**Vincentia Ratepayers and Residents Association Inc.
P O Box 149,
Vincentia,
NSW 2540.**

20th May 2011

Vincentia District Centre (MP06_0025) Mod 3

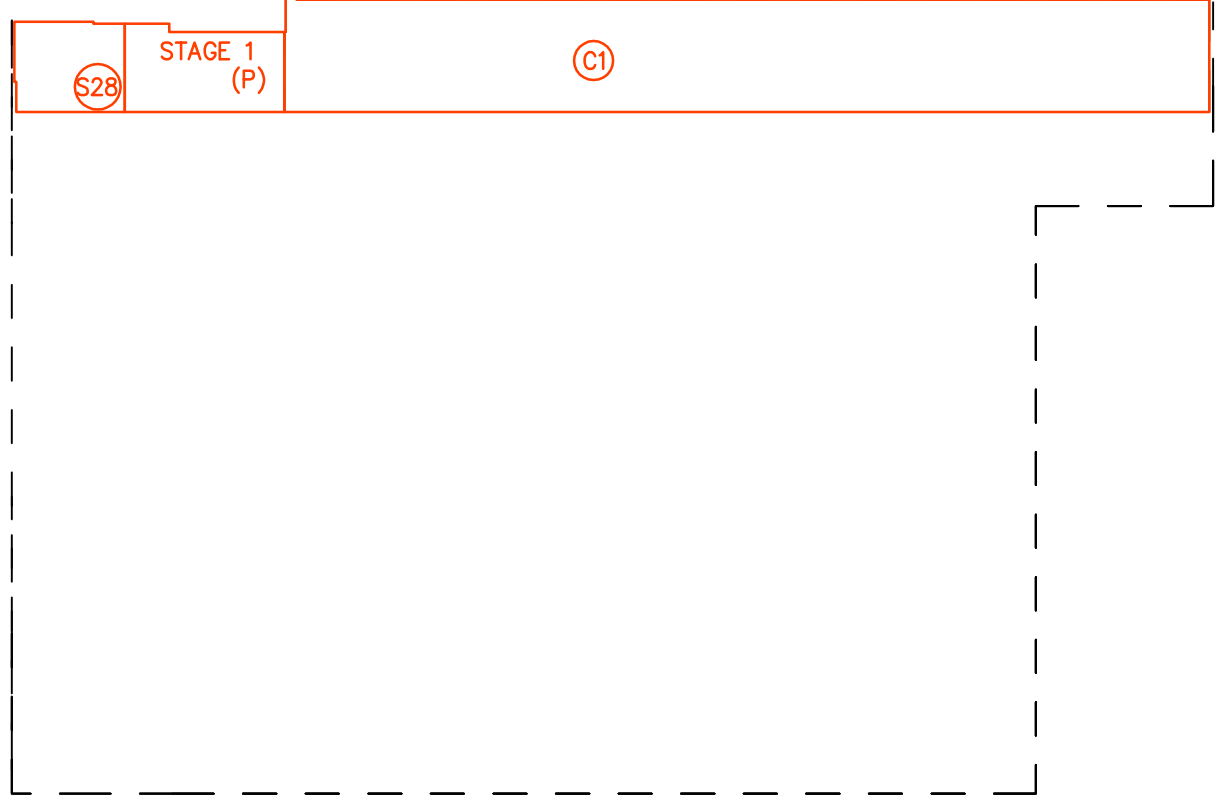
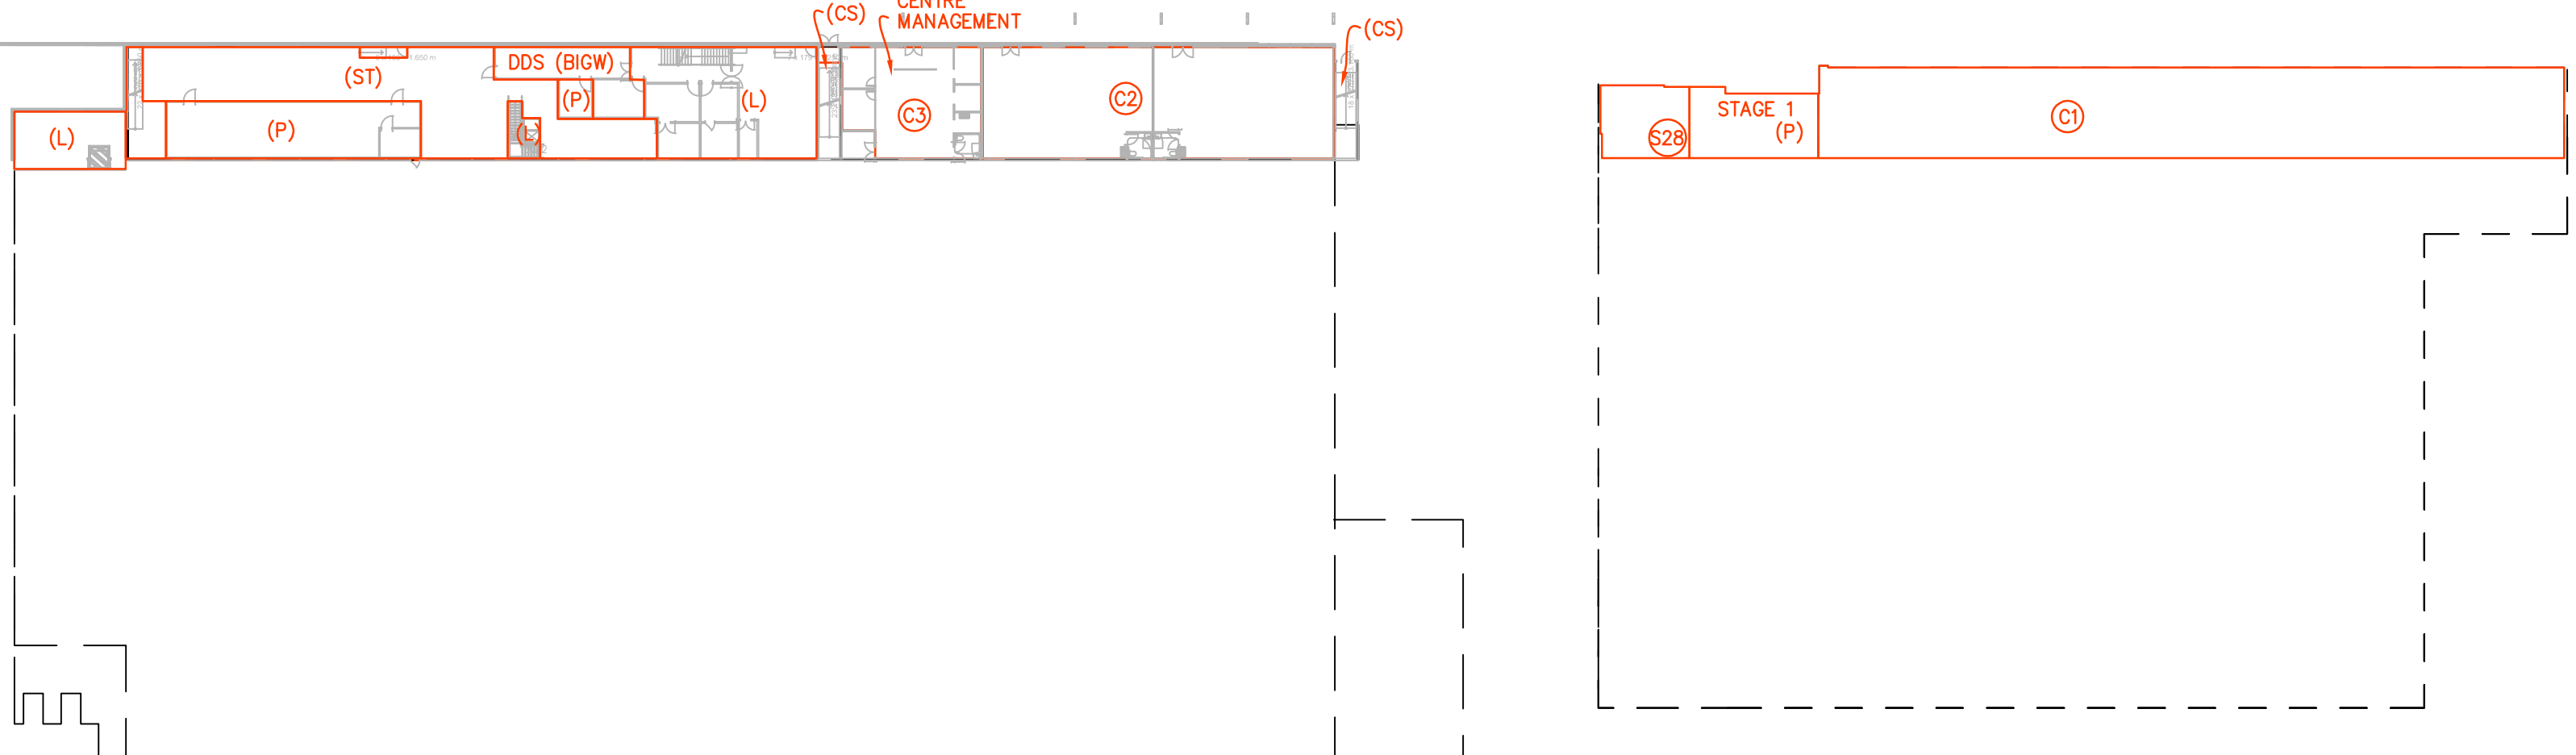
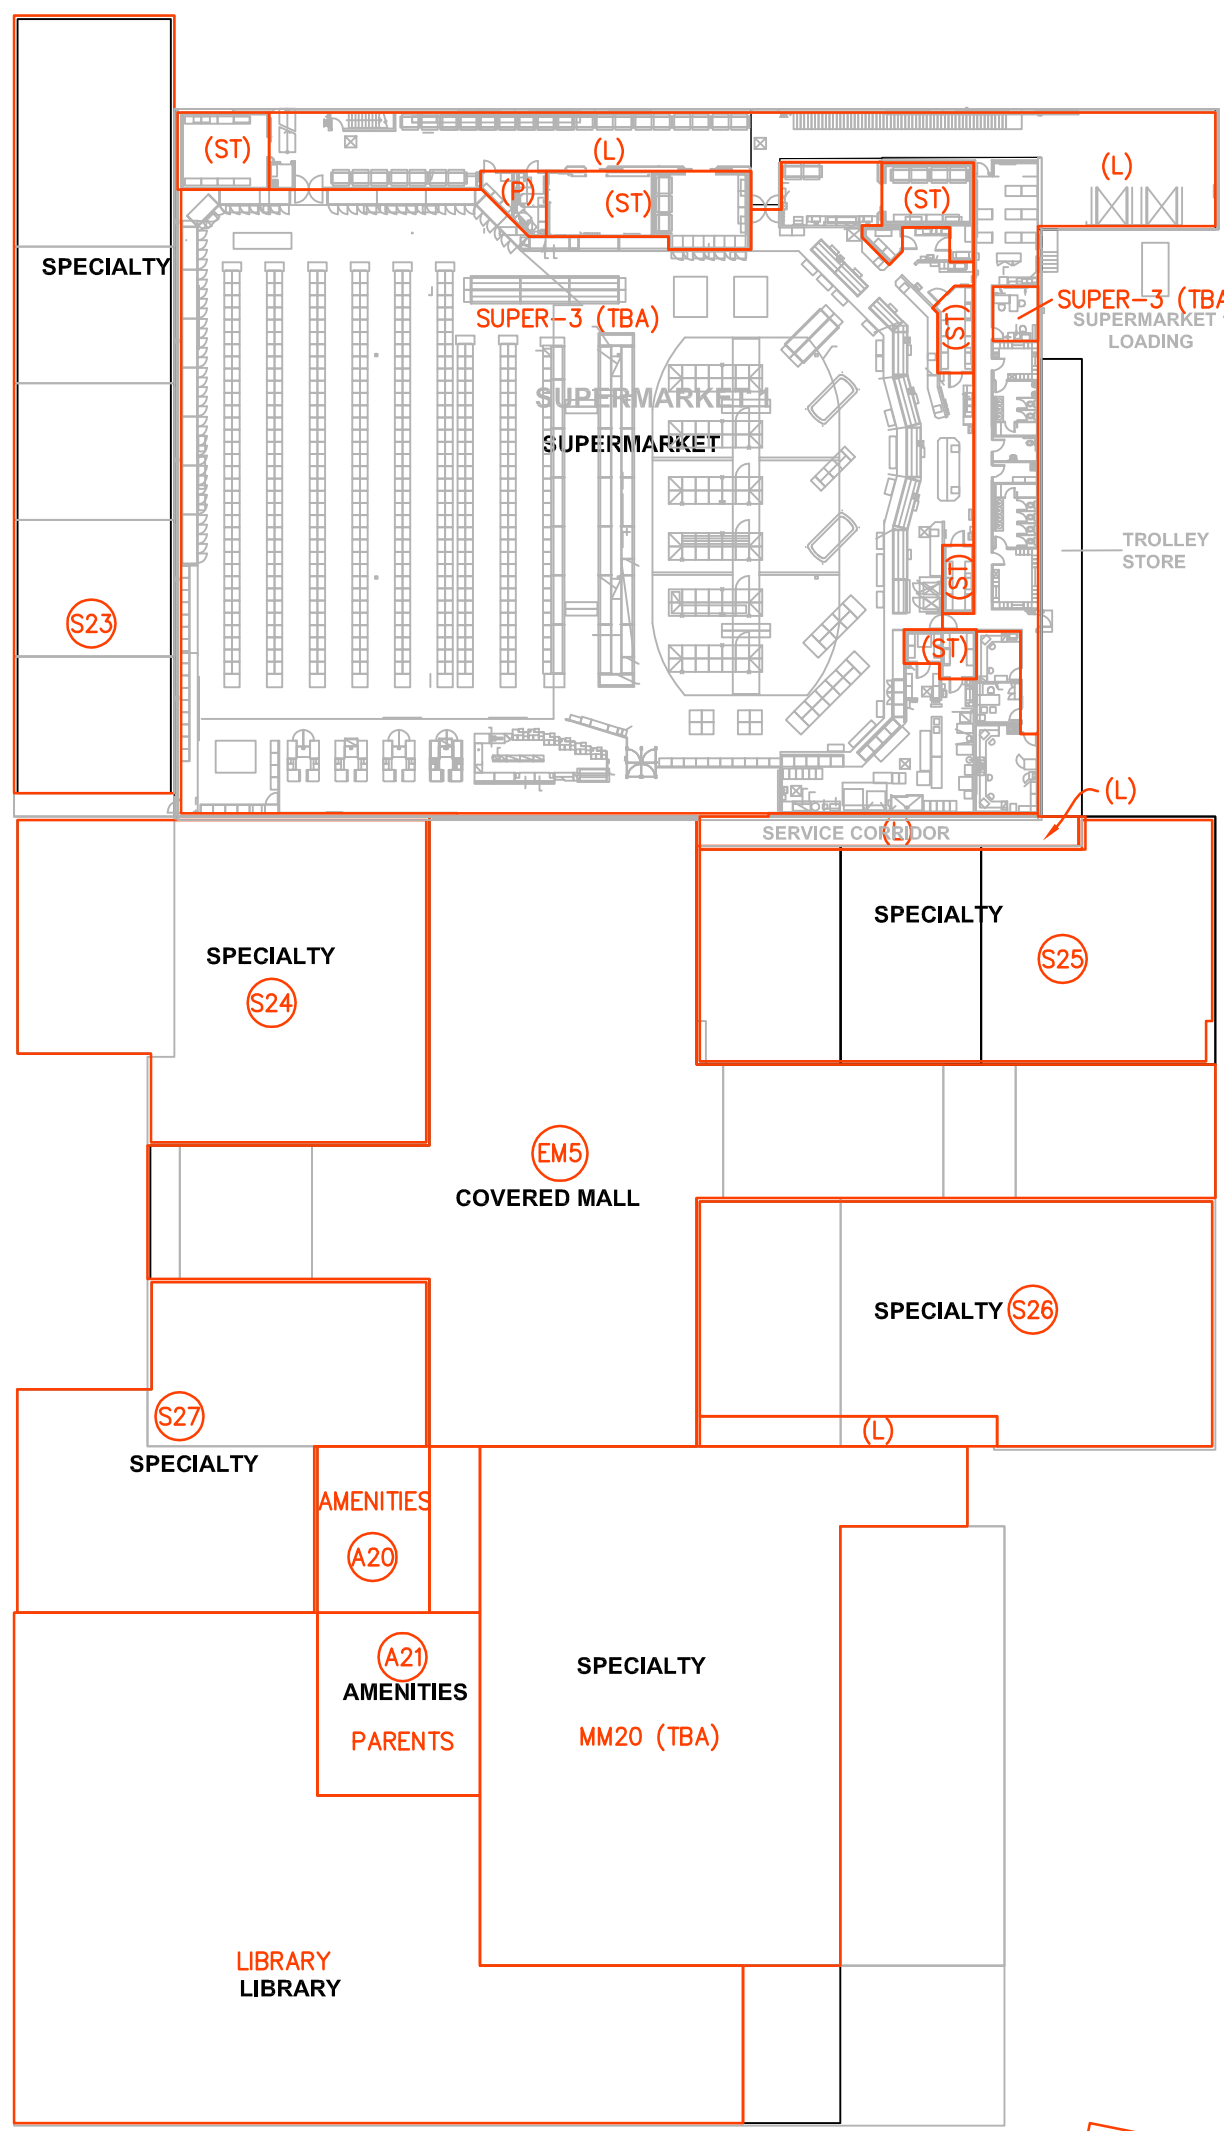
The proposed revision of the car parking appears to lack the shade trees in the parking lines shown in Mod 2 and also the shielding of the car park from Naval College Road appears minimal. We draw your attention to the vision quoted above and the concept of "*building in the bush*". We would not wish to see such a large car park without trees to soften the visual impact both internally and from the main road. We note the deletion of car parking behind the Big W and adjacent to the Library site which is discussed below.

There seems to be little effort in the design to reduce conflict between pedestrians and traffic in the main carpark. The main flow of traffic is across the entrance face of the centre. Those accessing the centre entrance are required to walk along the roadways and cross this main access route. The design may be better served by moving the main access road away from the building, or integrating the pedestrian ways to further reduce conflict. There is no reason that pedestrians should be secondary in a car park when the intent is to allow troublefree movement between vehicles and the centre.
